Demolition of 1 No. existing house & grounds & erection of 2 No. new detached dwellings. This application may affect the character & appearance of the Station Road, East Preston Conservation Area.

St Marys Close Hurst Road Rustington

Thank you for your internet representation made on 11th October 2018 which has been recorded as '**an objection**' with the comments as follows:

Drawing Title:
ADDITIONAL DWELLING
PLOTS 1 & 2
ELEVATIONS

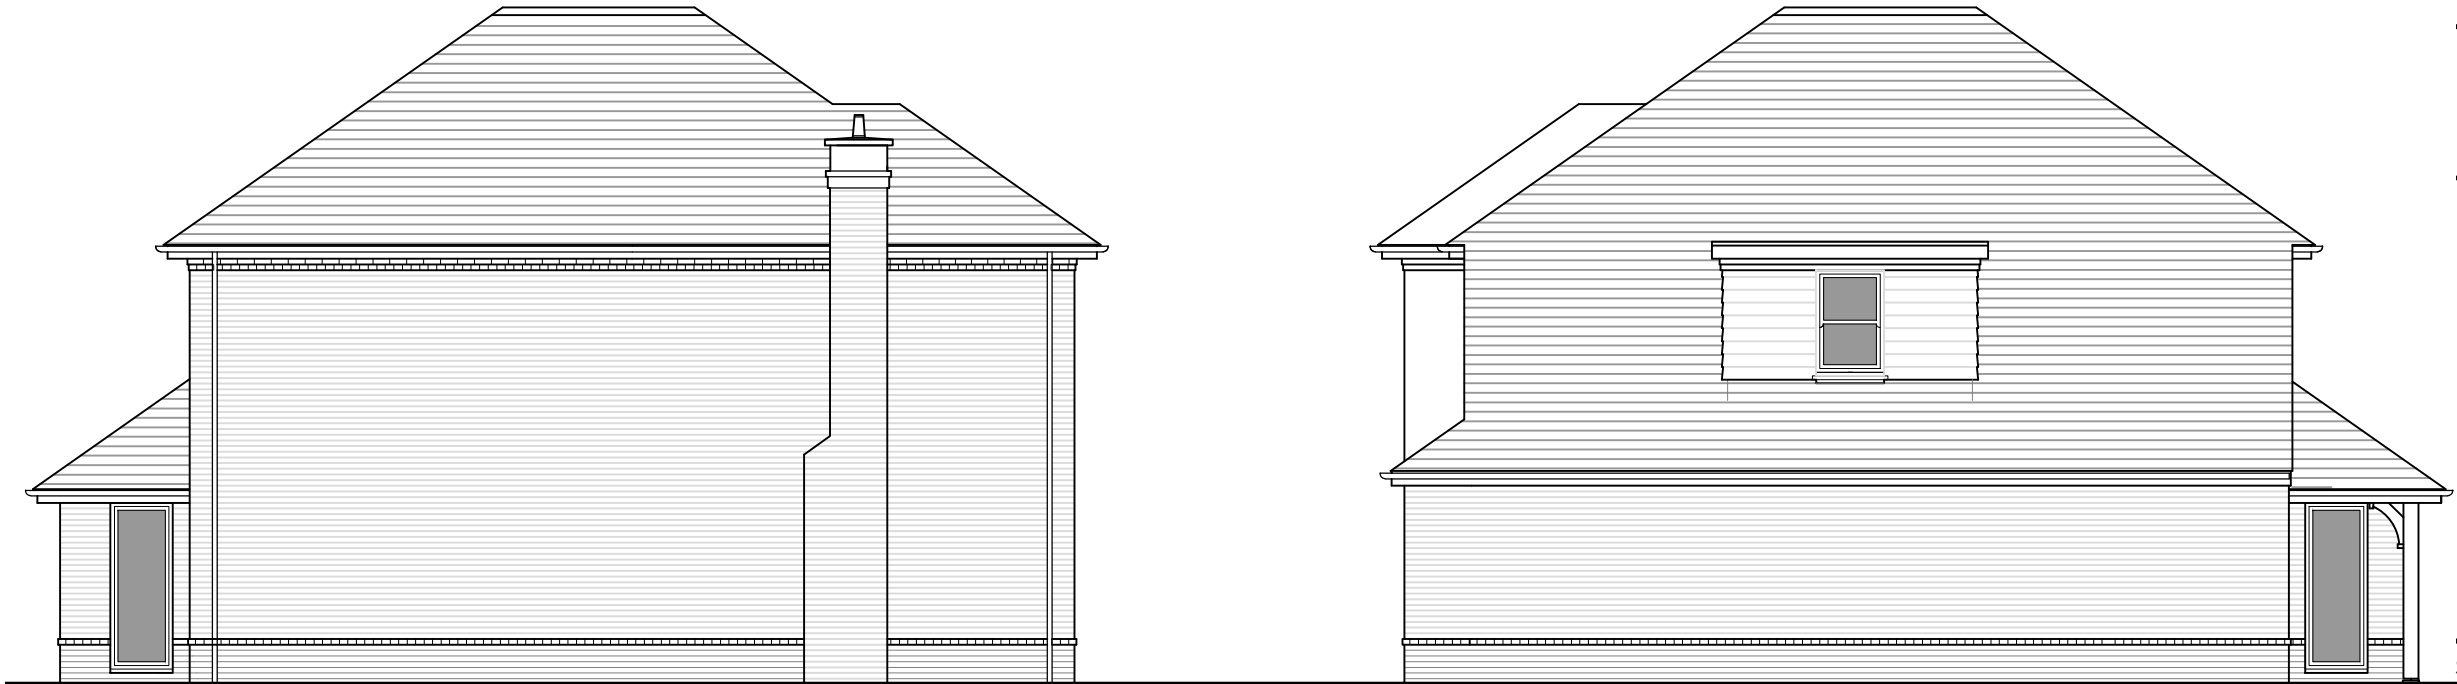
Design & visual impact - We are disappointed that the developer has submitted proposals for two houses of exactly the same design, using the same materials & with the same orientation, especially as this was explained to him in the original objections that it was one of the problems with his first submission for this site. They do not fit with the individual properties in Hurst Road or with the road's overall appearance and character. In fact the proposed scheme contravenes the Local Plan - D SP1 Design 13.2.7 as it does not "Respect, improve and enhance the existing surrounding environment". Also the proposal has not followed the Rustington Neighbourhood Plan Policy 2 Housing Design particularly point 4.12 "Development should not detract from the character and amenity of the nearby area.

In conclusion we strongly object to this proposal. We believe that it will detrimentally alter the fabric of Hurst Road as these plans are completely unsympathetic to its unique appearance made up of 17 distinctive properties. Please will you take our objections into account when deciding this application and ask the developer to submit new plans for two different properties. Thank you.
